Marge Schmuckal - 6 Custom House Wharf

From: Marge Schmuckal
To: hallettcanvasandsails@gmail.com
Date: 6/20/2013 3:31 PM
Subject: 6 Custom House Wharf

You have recently applied for a permit for an awning at 6 custom House Wharf. This property is located in a Historic zone which requires a Historic review. Such review requires an additional fee. Please contact our front staff to pay that review fee.

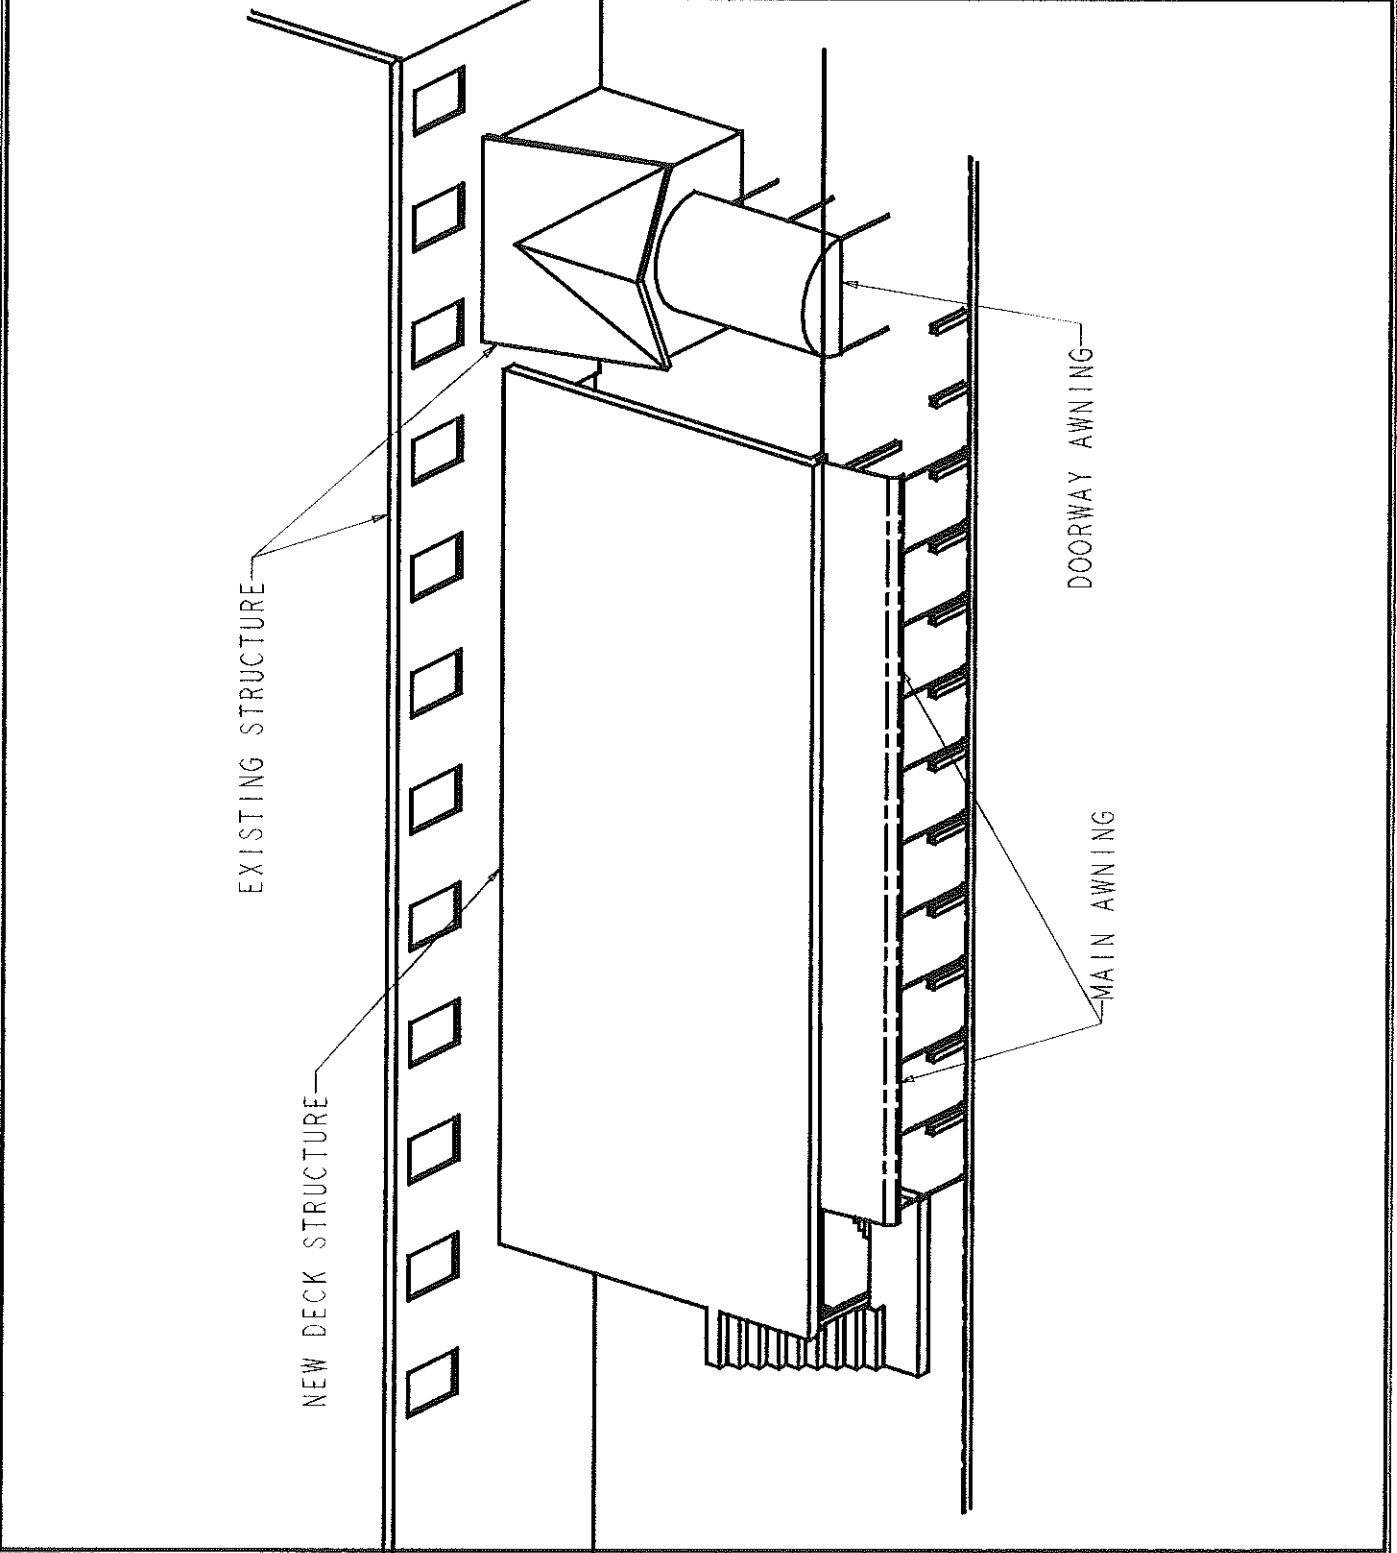
Your application is for an awning. Your drawing is showing to enclose the outdoor dining. The restaurant use is legally nonconforming and may not be expanded. Such enclosure constitutes an expansion of the use. If you were not to have any side curtains or windows or doors and erect just an awning, such a request could be allowed.
